# ENG-SF18025-R1-Plat\_Redlines.pdf Markup Summary

# ENG-SF18025-R1-FDR\_Redlines.pdf Markup Summary

# ENG-SF18025-R1-CDs\_Redlines.pdf Markup Summary

SF-18-025

SHEET: **CH1**

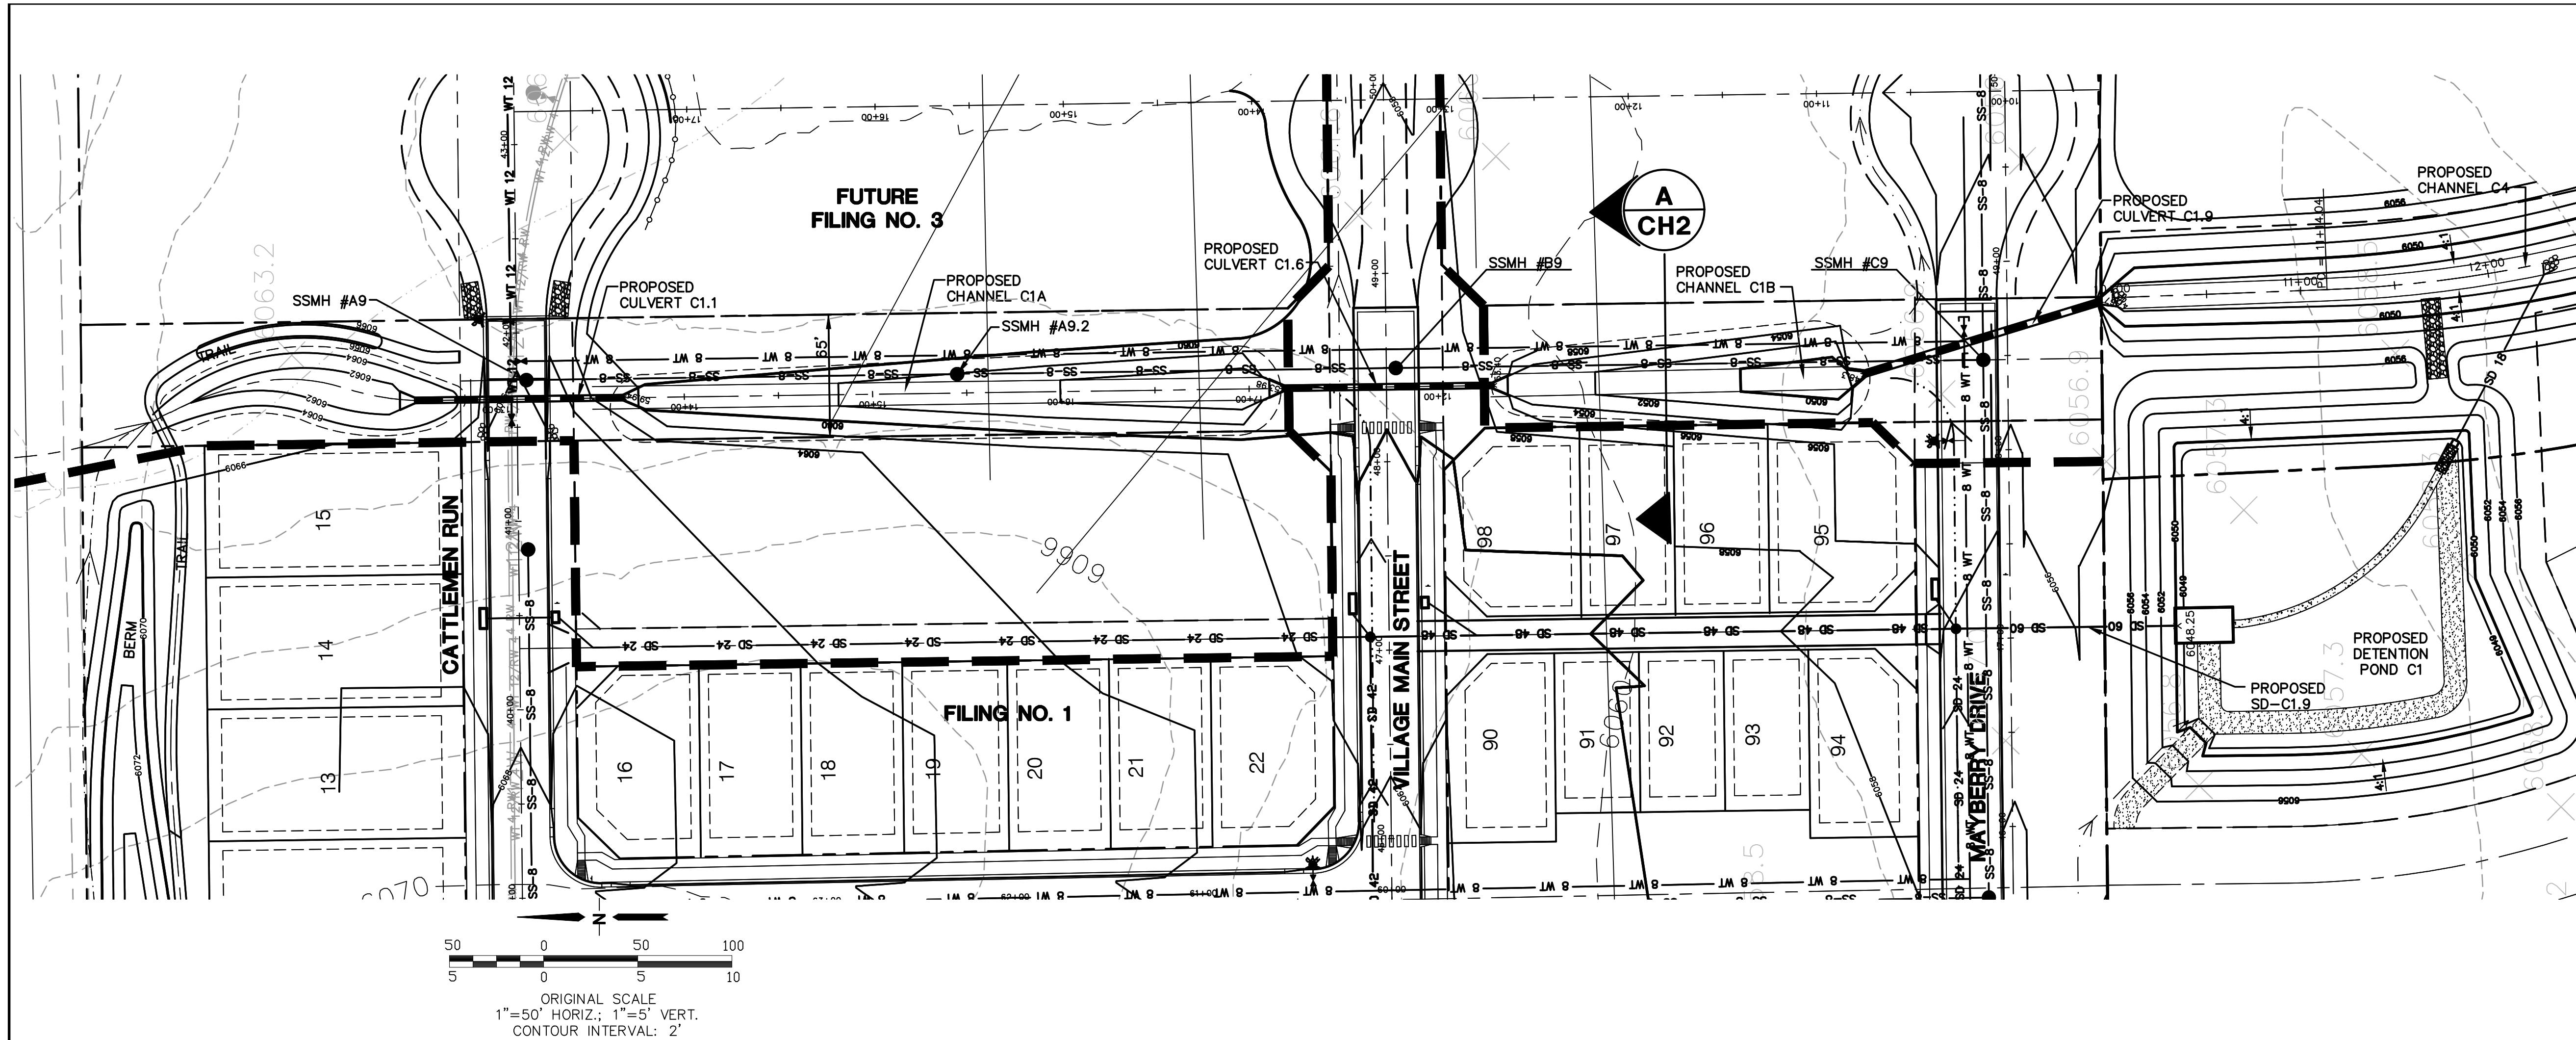
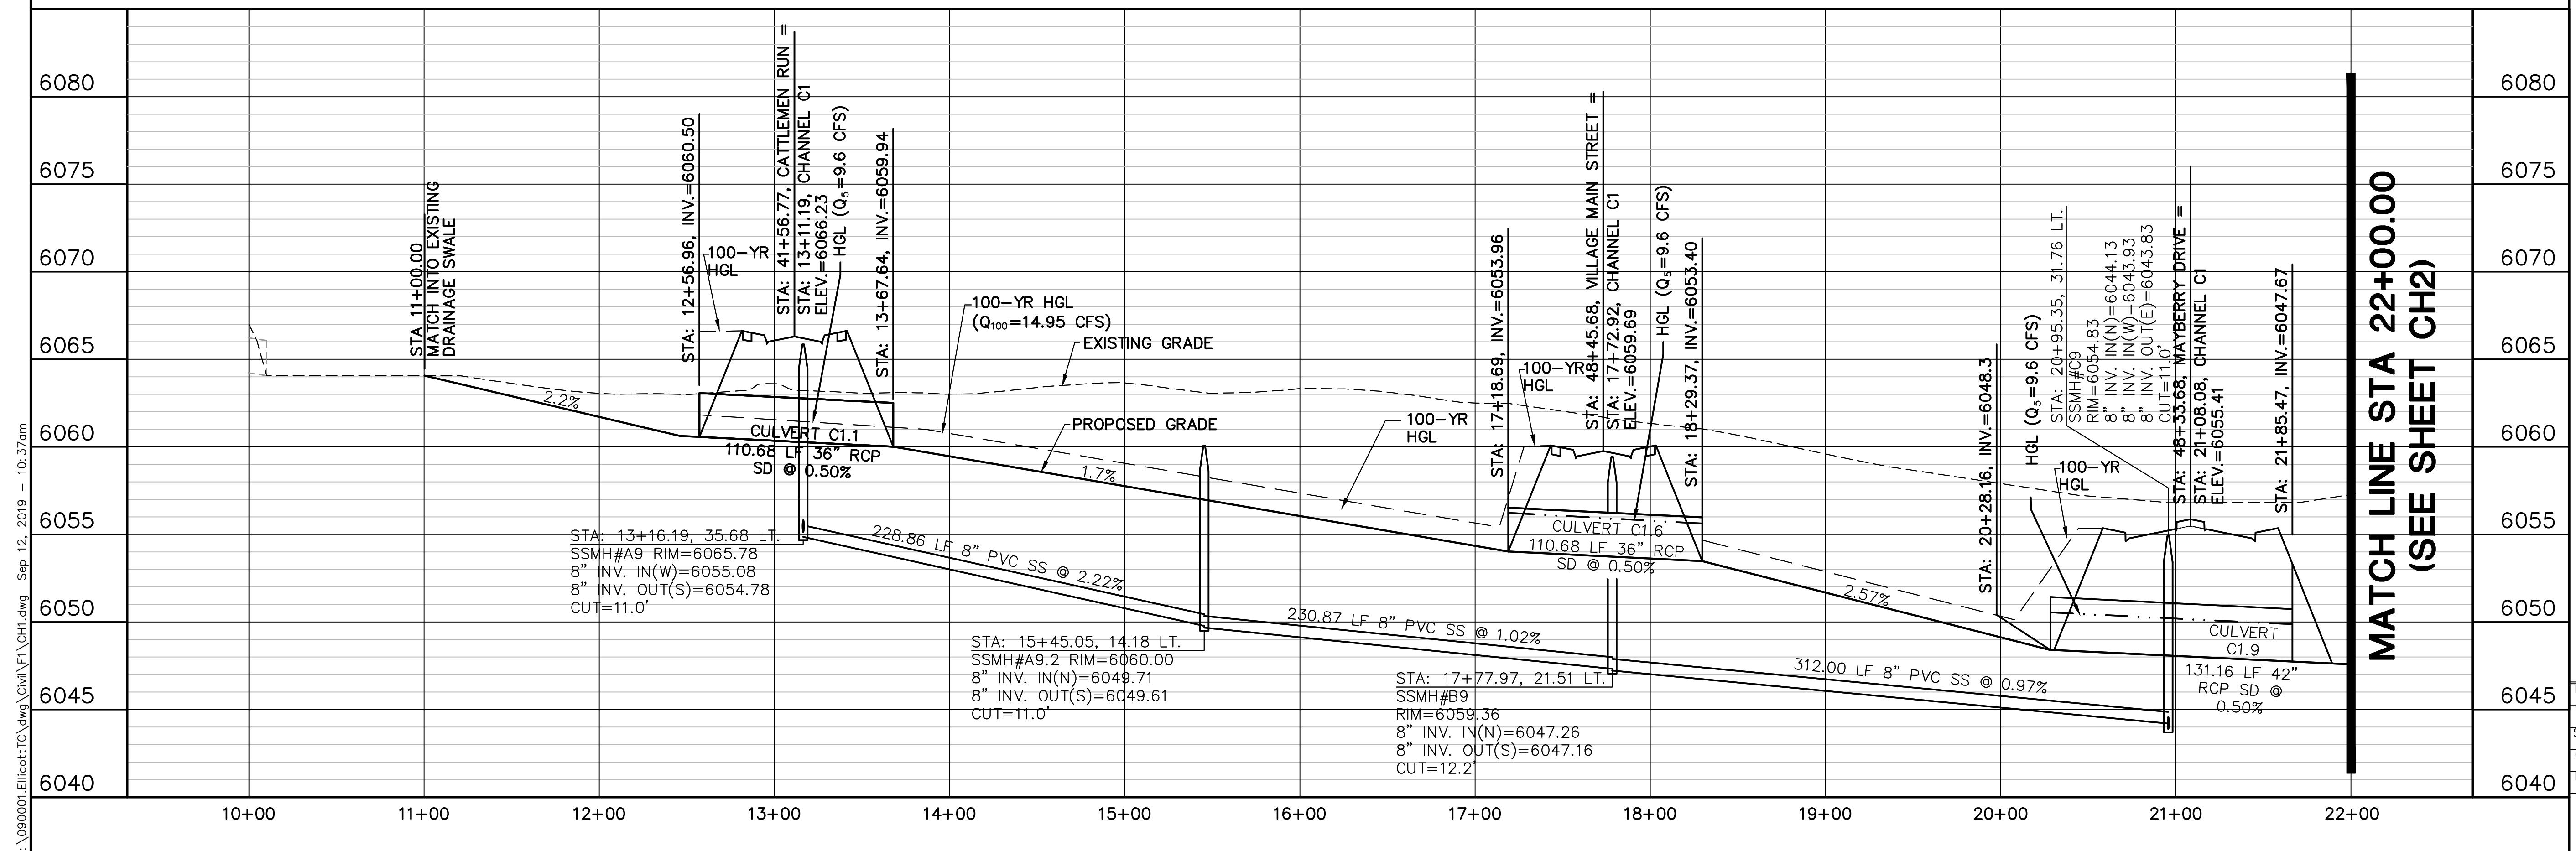
Spillway should not be directly over the pipe. Riprap will be sitting on the pipe. Provide profile and detail.

HORZ. SCALE: 1"=5'	DRAWN: RMD
VERT. SCALE: AS SHOWN	DESIGNED: JPS
SURVEYED: 9/12/19	CHECKED: JPS
CREATED: 5/5/05	LAST MODIFIED: 9/12/19
PROJECT NO: 090001	MODIFIED BY: BJJ
SHEET: TY2

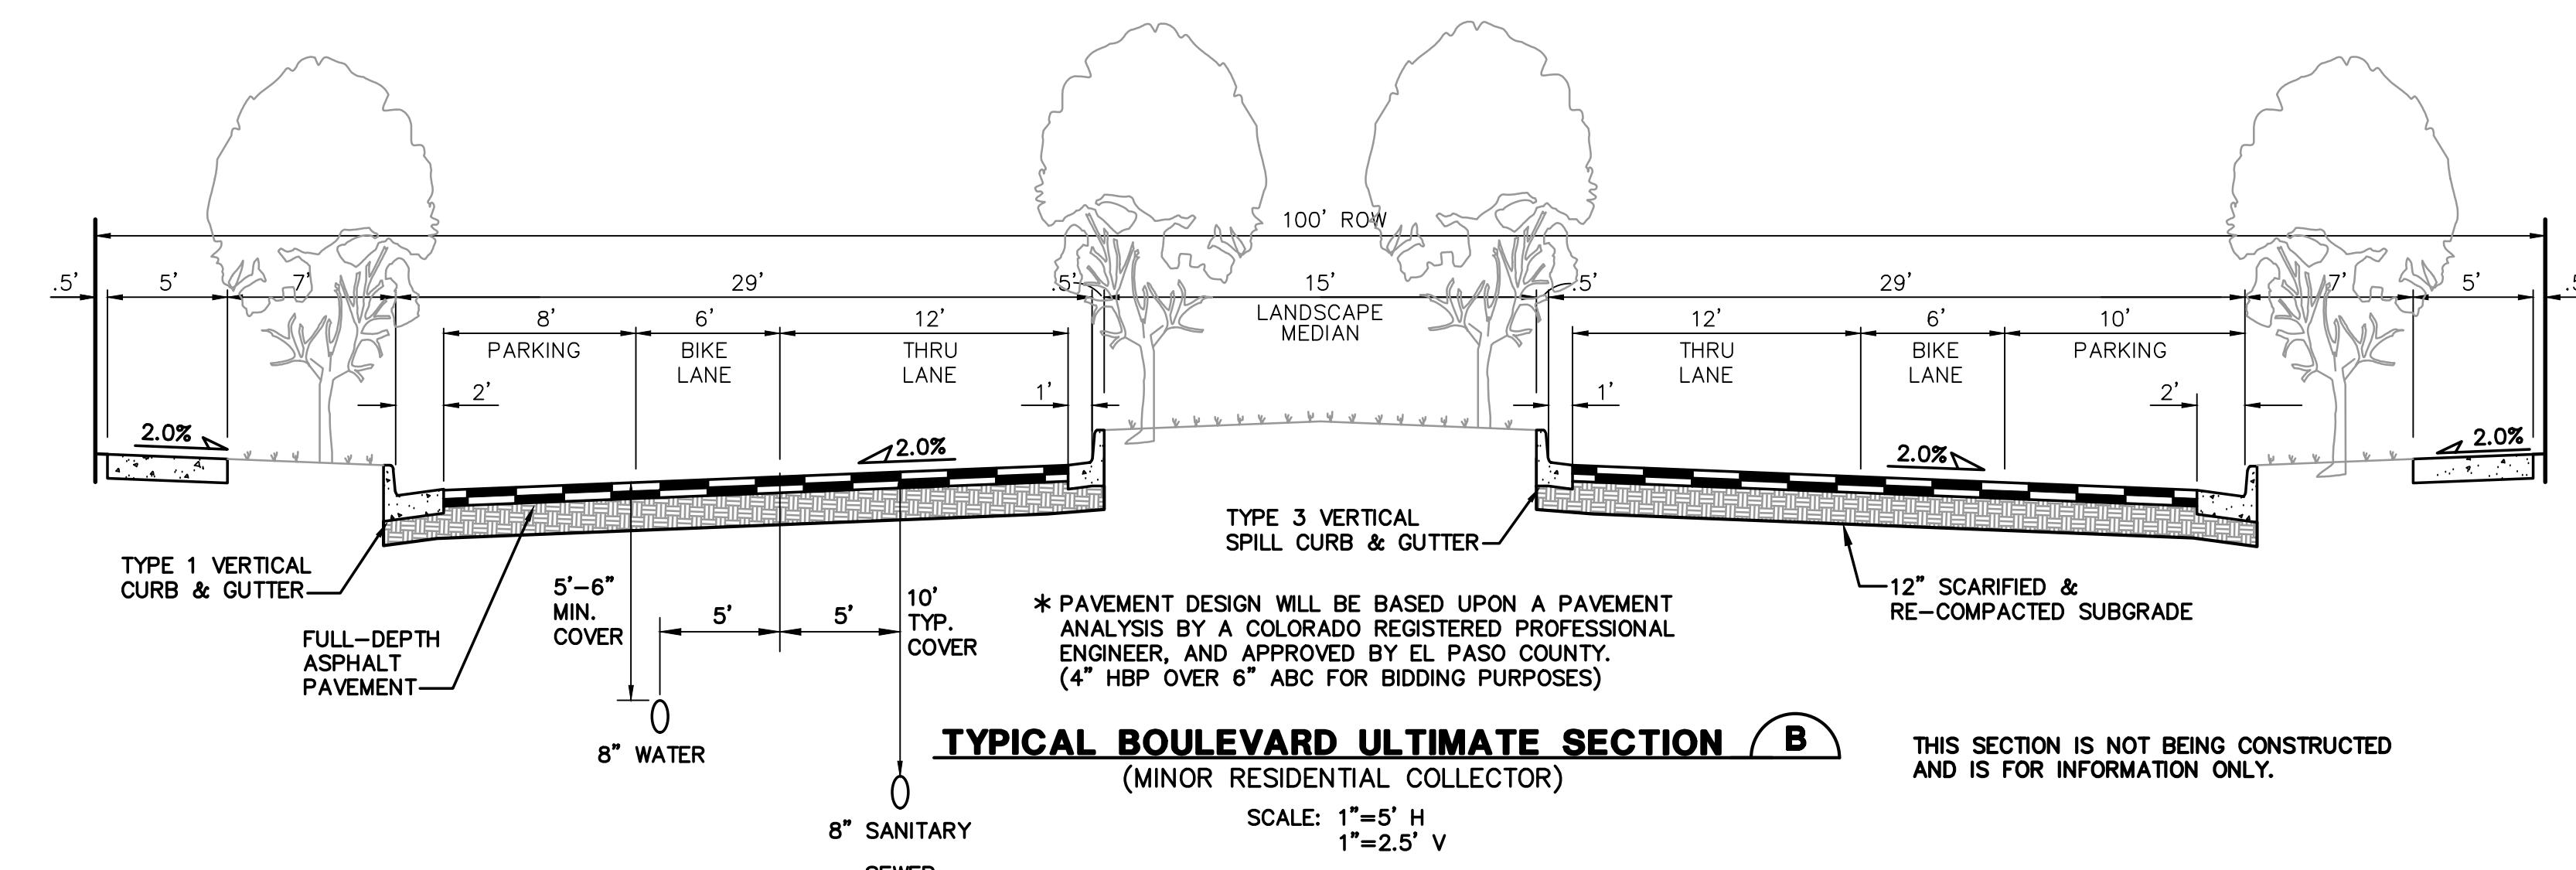
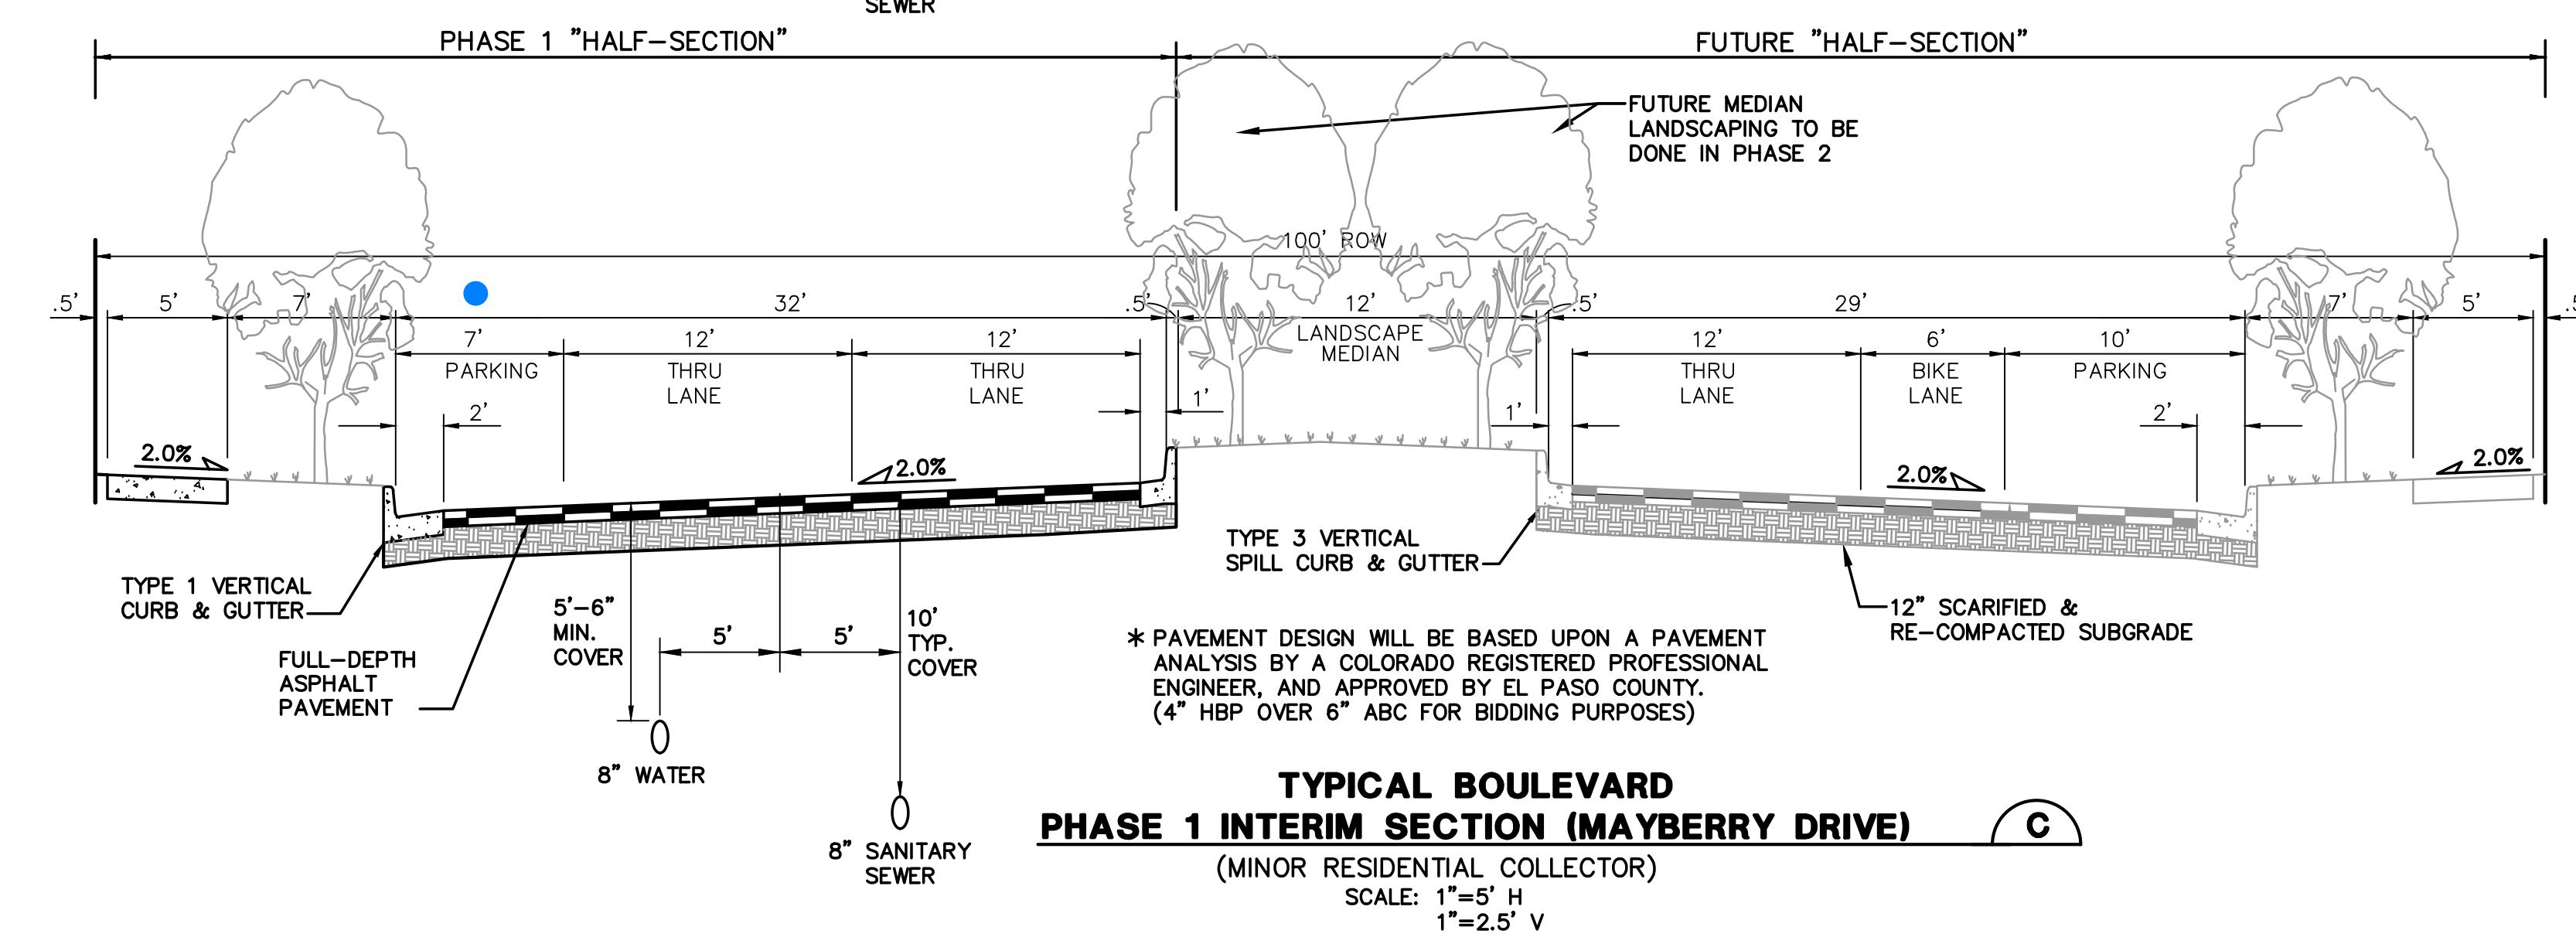
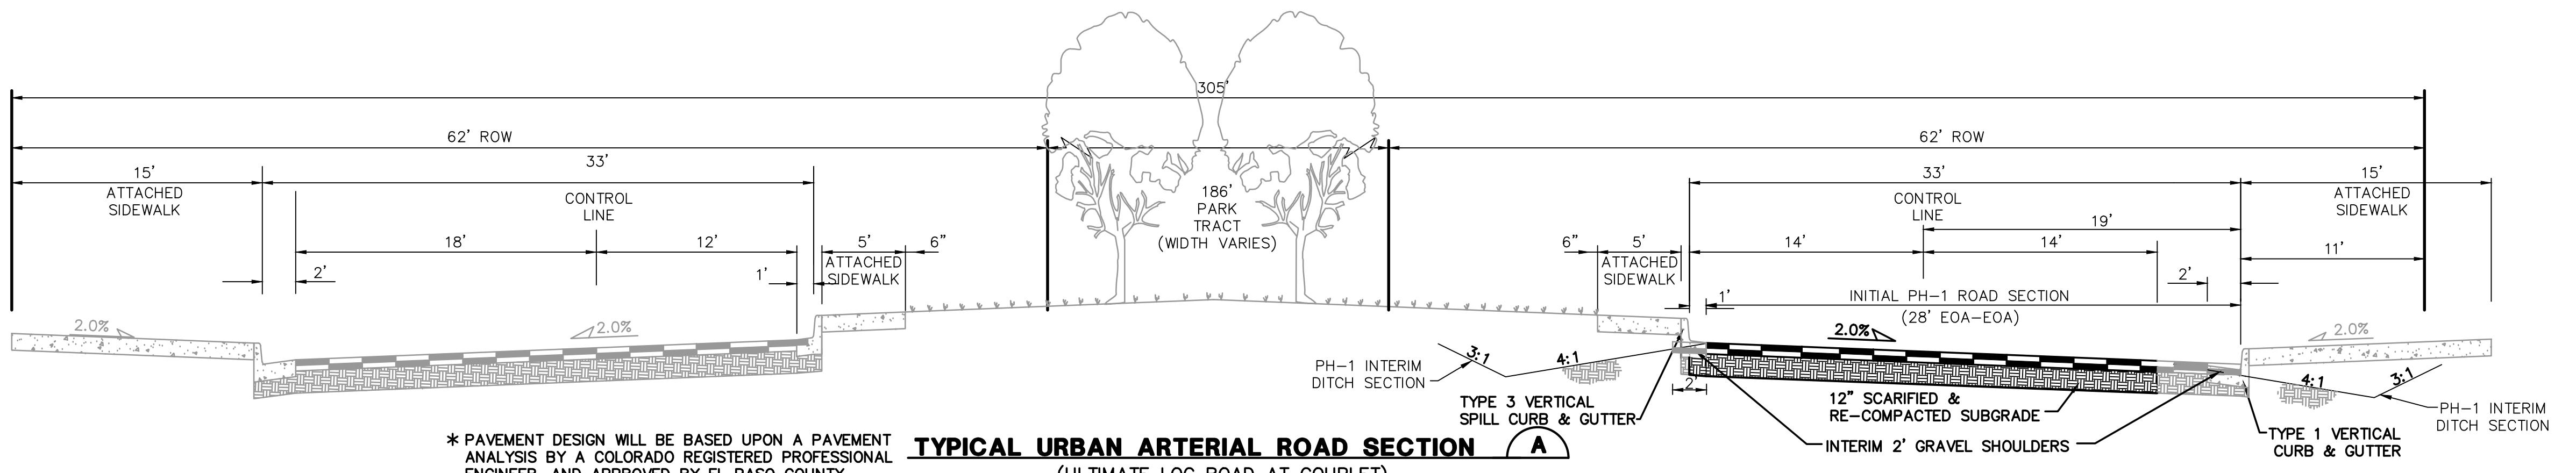
TY2?
